Chau Chak Wing Museum, University of Sydney (SSD 7894) - Notice of Exhibition

Thank you for your letter dated 6 June 2017, requesting Transport for NSW (TfNSW) review and comment on the above.

Proposed Site Cross Section, Looking South through Loading Dock Access

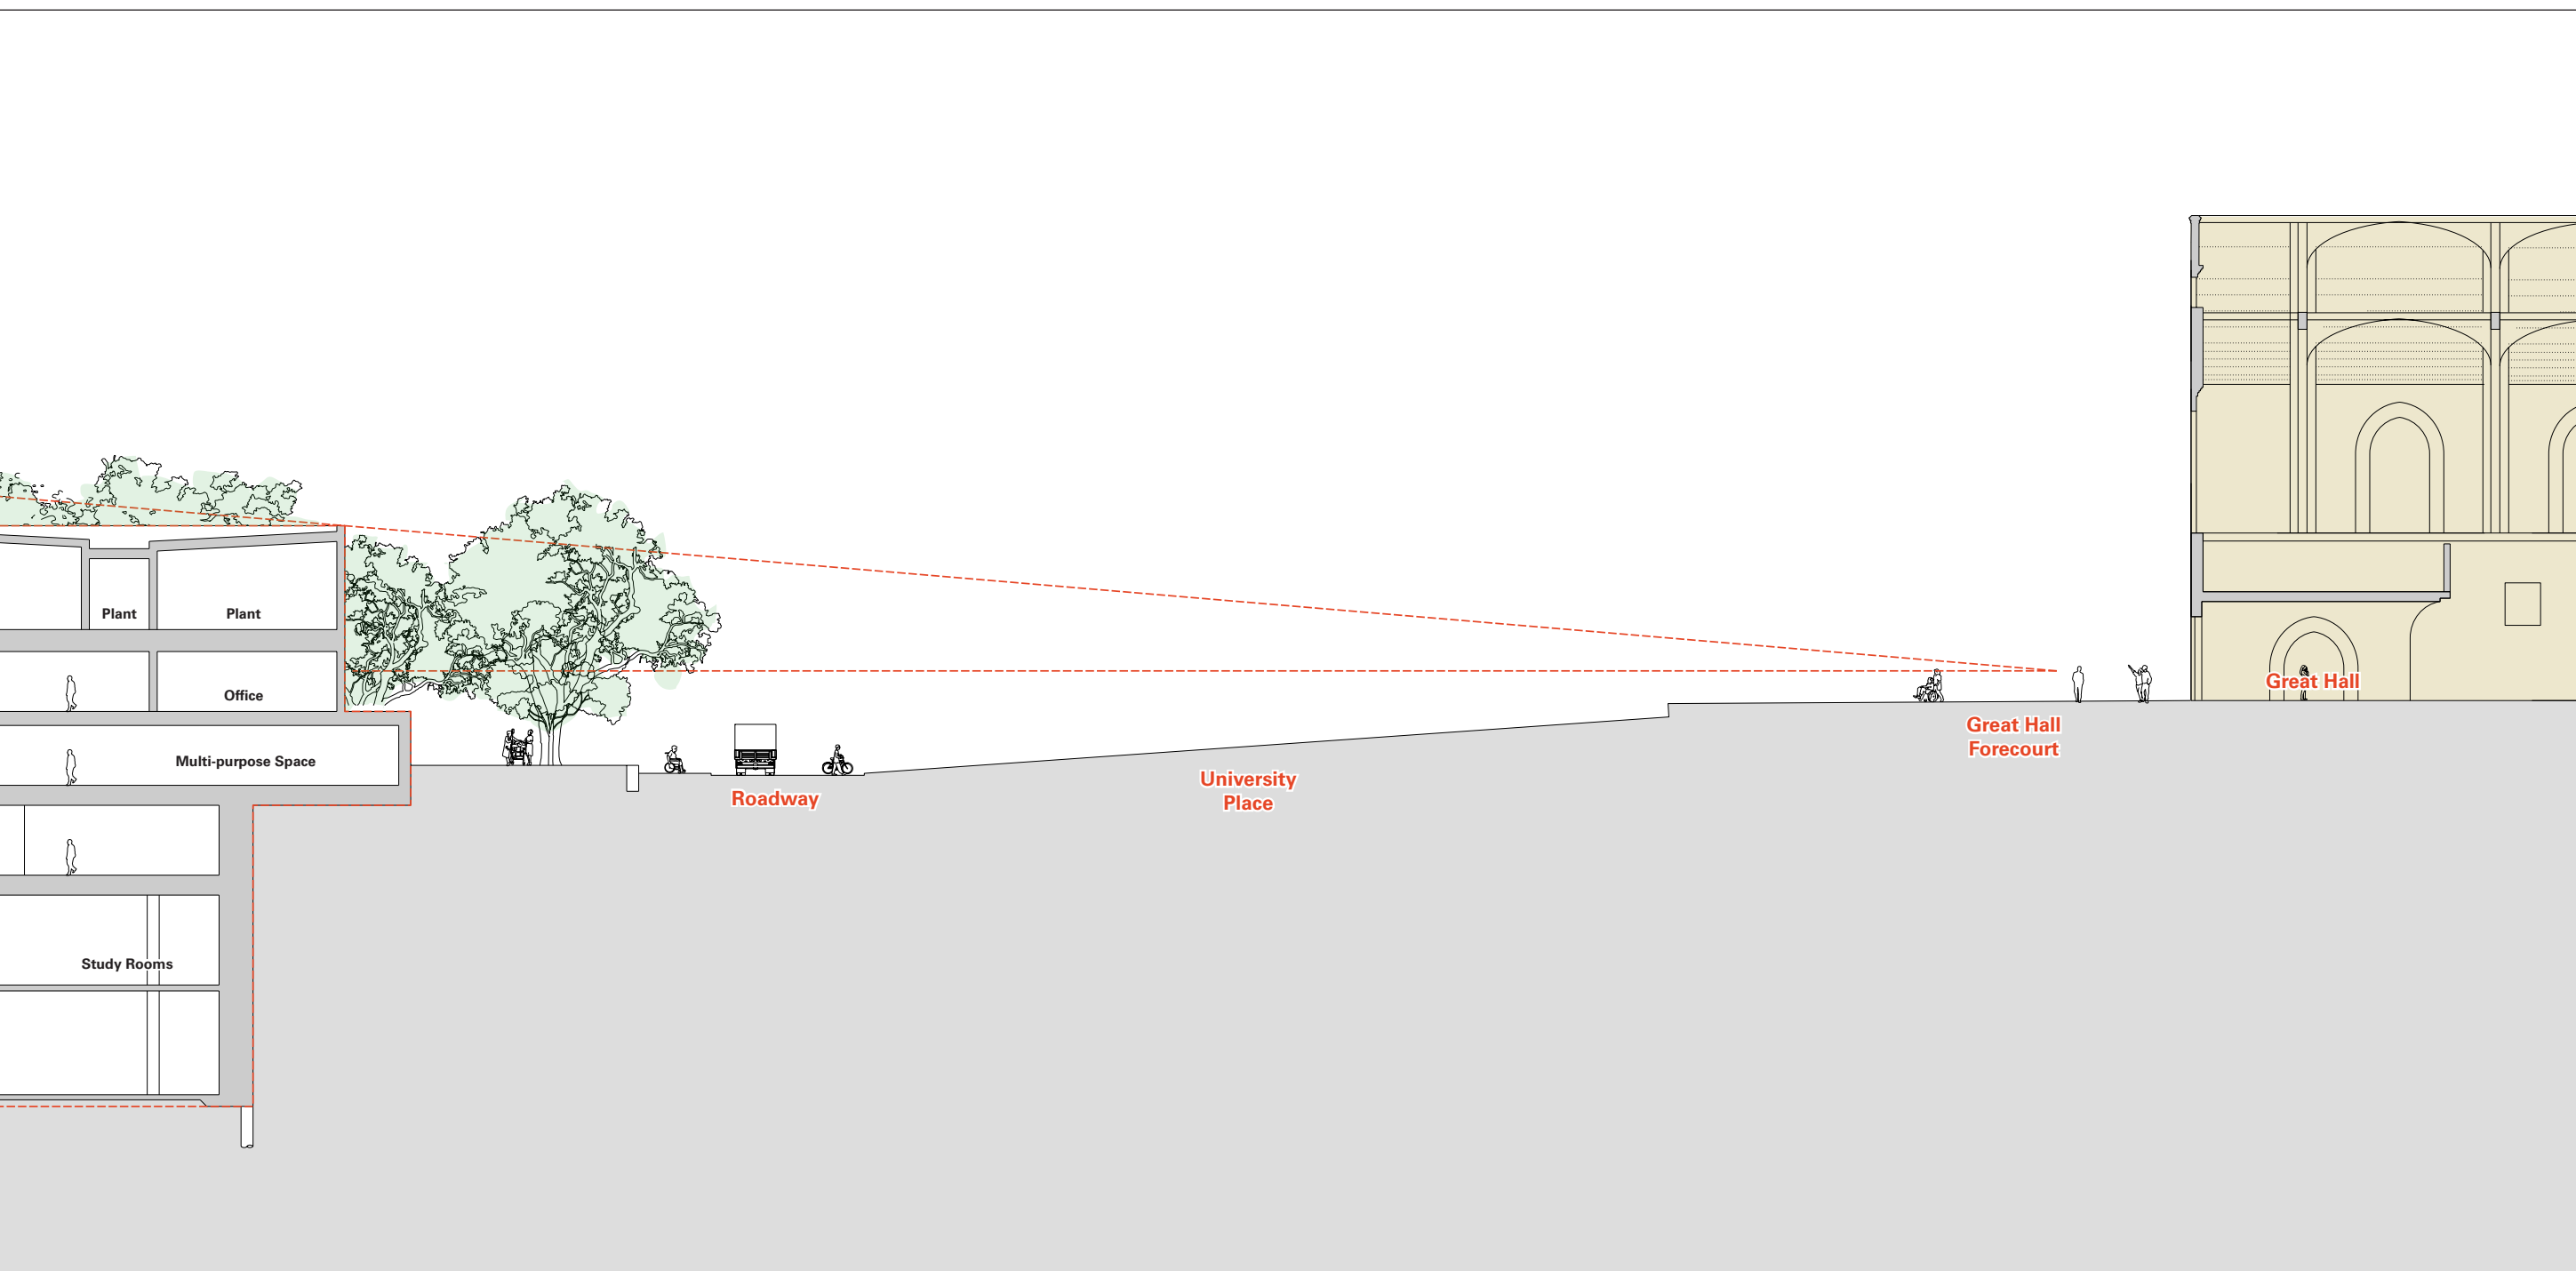
Section 9.1 (Vehicle Access Arrangements) of the Transport Impact Assessment (Traffic Report) states that the loading dock entry is located 25m from the Parramatta Road entry which provides room for three vehicles to queue on exit before blocking the ramp access. TfNSW advises that the loading dock entry is located in close proximity to Parramatta Road. The proposed loading dock entry arrangement would have the potential to cause queueing of vehicles to Parramatta Road and would have an impact on bus operations along Parramatta Road.

TfNSW requests that the applicant prepare a Loading Dock Management Plan to ensure that the operation of the loading dock do not cause queueing of vehicles on Parramatta Road and do not have an impact on bus operations along Parramatta Road. The management plan needs to include the following (not limited to):

- Details of measures to ensure that the operation of the loading dock do not cause queueing of vehicles on Parramatta Road;
- Details of incident management at the access to the loading dock;
- Loading dock management details including service vehicle movements during peak periods; and
- Management of conflicts between pedestrians walking on footpath and the service vehicles using the loading bays.
